Lots 3 & 4 Bill Avery Road

Re: Status of Improvement Permit Application #09-5-21723 & #09-5-21710R

An attempt was made to evaluate your property for the purpose of issuing an Improvement Permit. The evaluation could not be completed for one or more of the following reasons.

SITE PLAN APPROVAL  
 DISTRICT RA 30 USE DUREX  
 #BEDROOMS 1800s 2 UNITS 2 BATHS EA & 2360 EA  
 1/2 OR 1/4 TOTAL

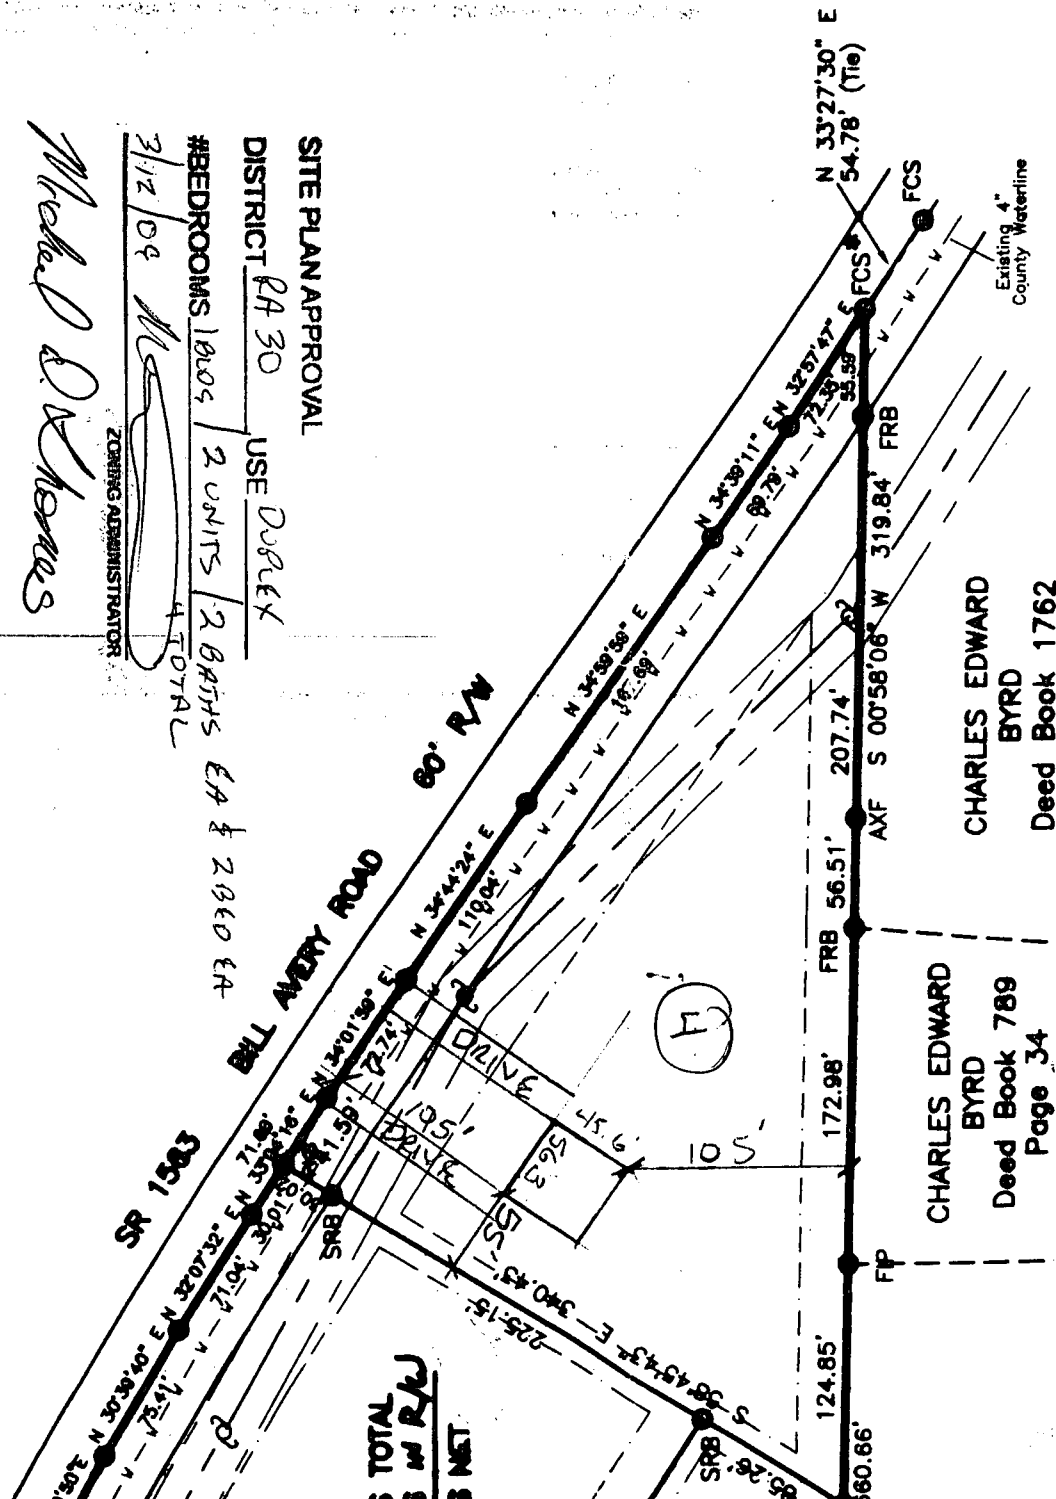
- 1. Property lines/corners not marked or labeled *(\$25.00 fee incurred)*
- 2. House corners not marked or labeled *(\$25.00 fee incurred)*
- 3. Directions not clear to property *(\$25.00 fee incurred)*
- 4. Property needs brush or vegetation removed
- 5. Backhoe pits required
- 6. **Other – Setbacks are incorrect on both lots.**
